Your Ref:
Our Ref: FP/152/08/
Please ask for:
Mr M Porter

27th August 2008

Change of use from highway verge to private garden and erection of 1.8m high brick boundary wall

1 Poulner Close Felpham

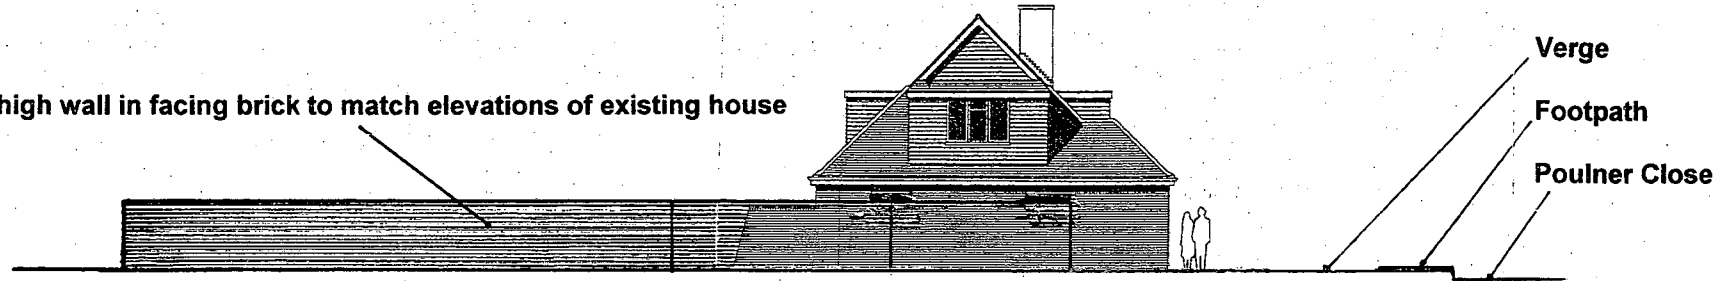
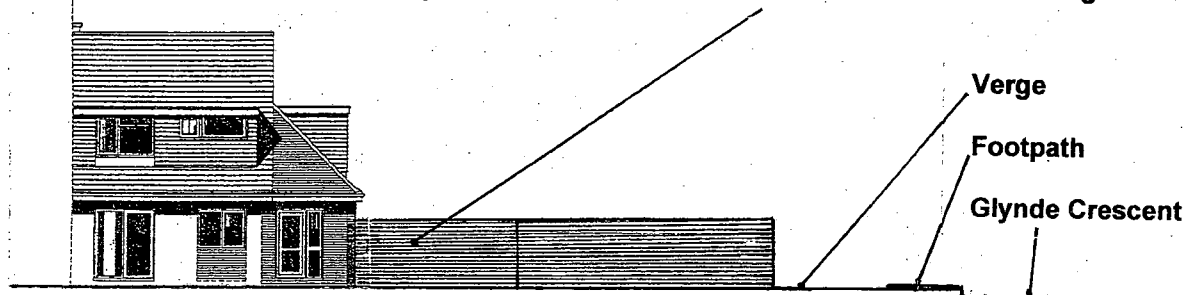
The planning committee object strongly to this application on the following grounds: There will be a severe impact on the street scene, relacing an open space and trees with a high brick wall and the consequential loss of visual amenity. The trees which would be subsumed into the applicants garden were provided by public money from the council. There would also be a loss of open space which would set a dangerous precedent for other similar small open areas in the future.
